Tel: 01903 737756
Email: planning@arun.gov.uk
www.arun.gov.uk/planning
Please ask for: Amy Anderson
Email: amy.anderson@terraquest.co.uk
Telephone: 0121 234 1390
Our Ref: M/98/25/HH
Your Ref:
Date: 19th December 2025

Application for Planning Permission for Works or Extension to a Dwelling

Development: Extension and alterations to form a rear facing balcony and sliding doors (part retrospective).
Location: 1 Elmer Court Elmer Middleton-On-Sea PO22 6JT

BAR/101

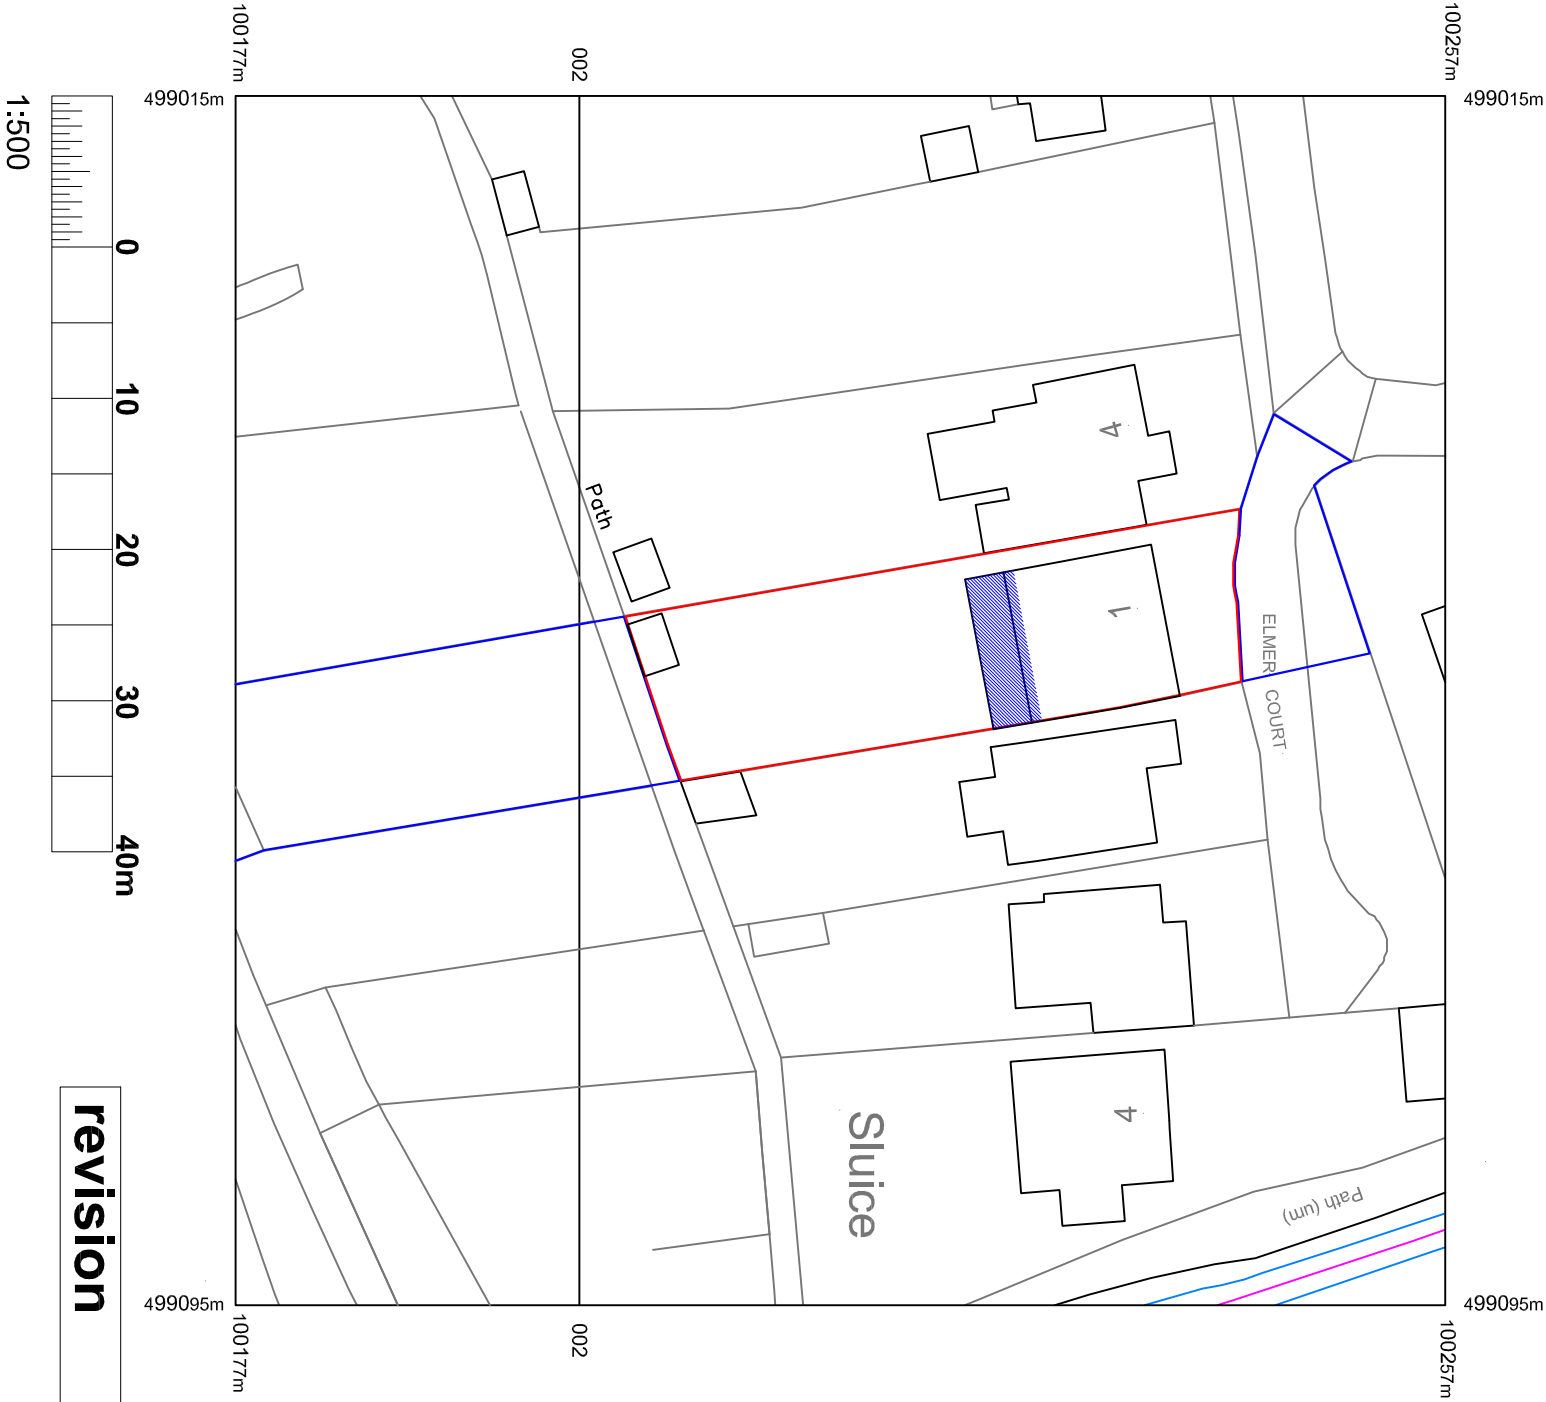
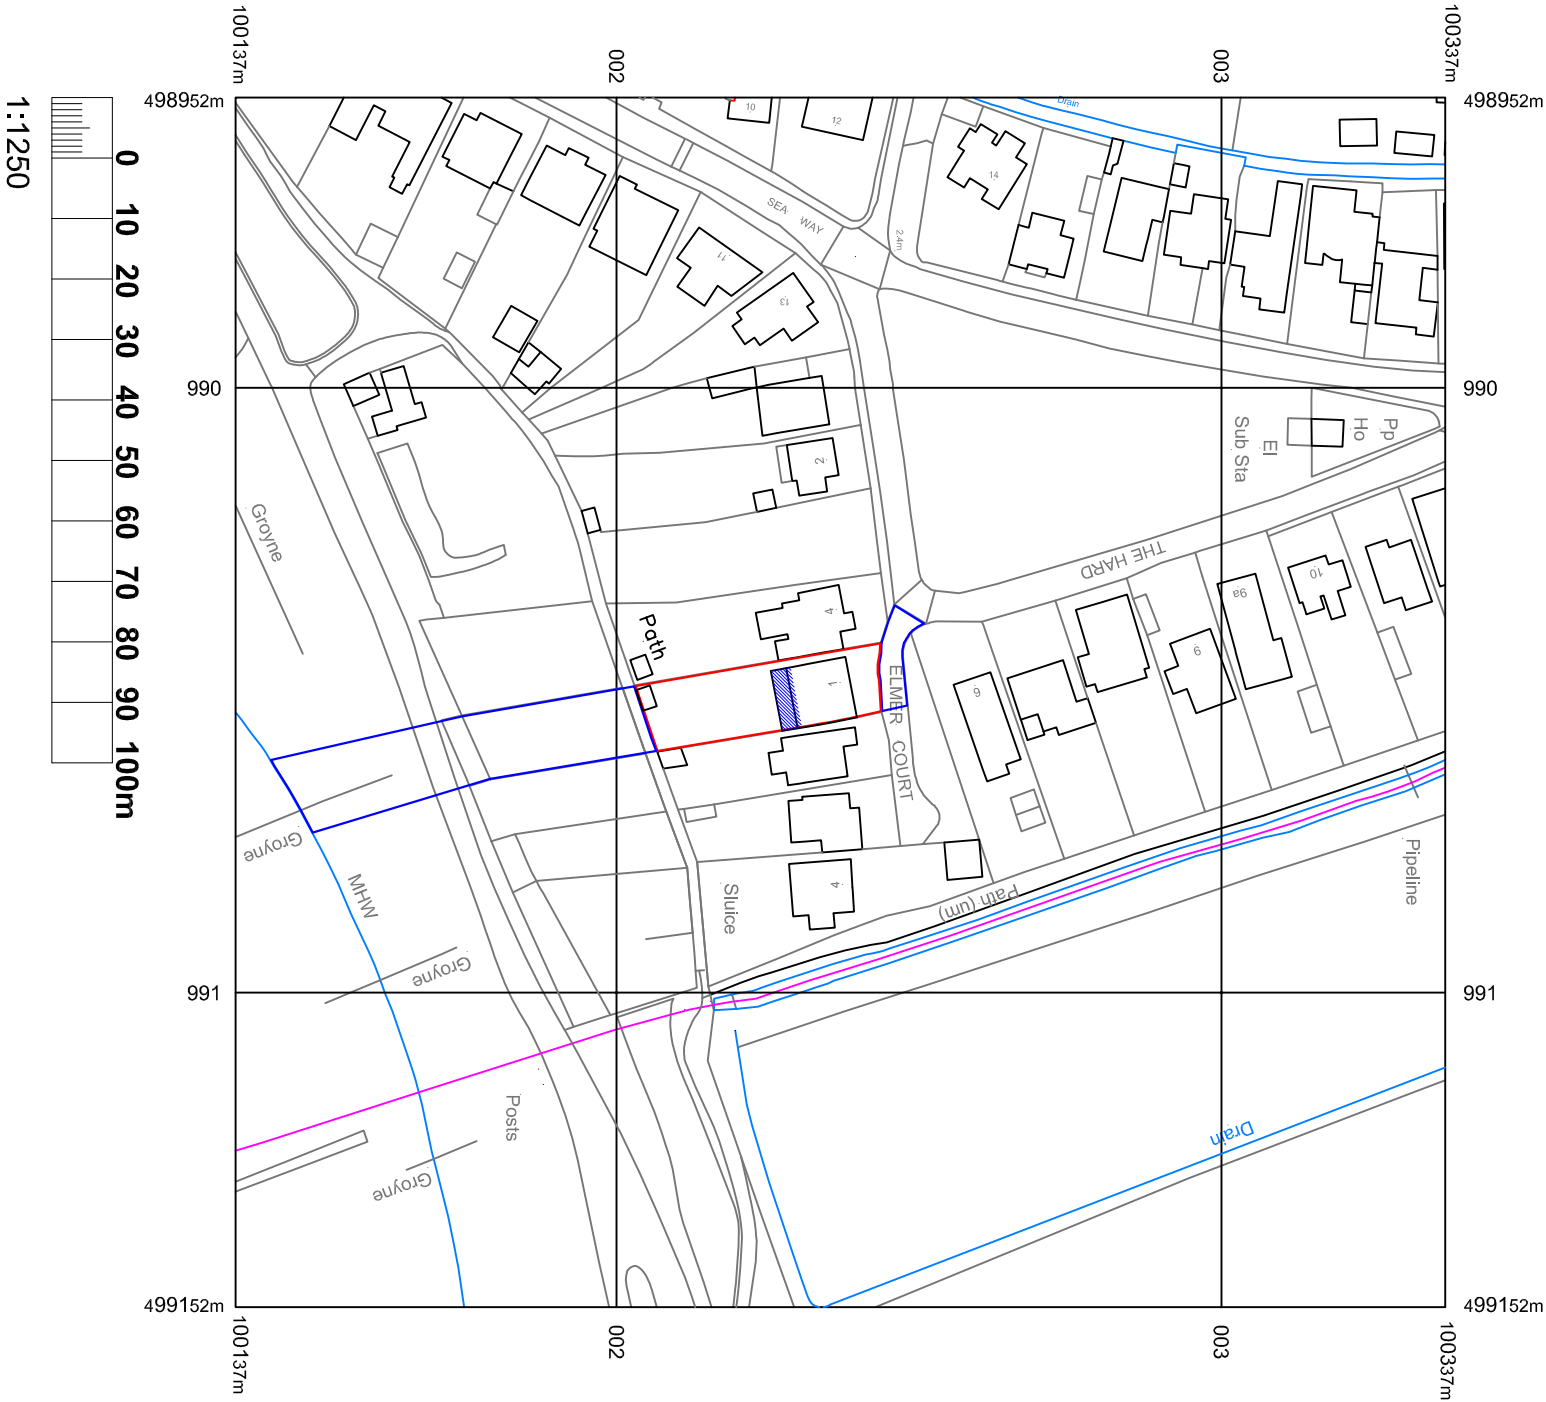
Site Plan - Please add the dimensions from the proposed balcony extension to each site boundary edge.
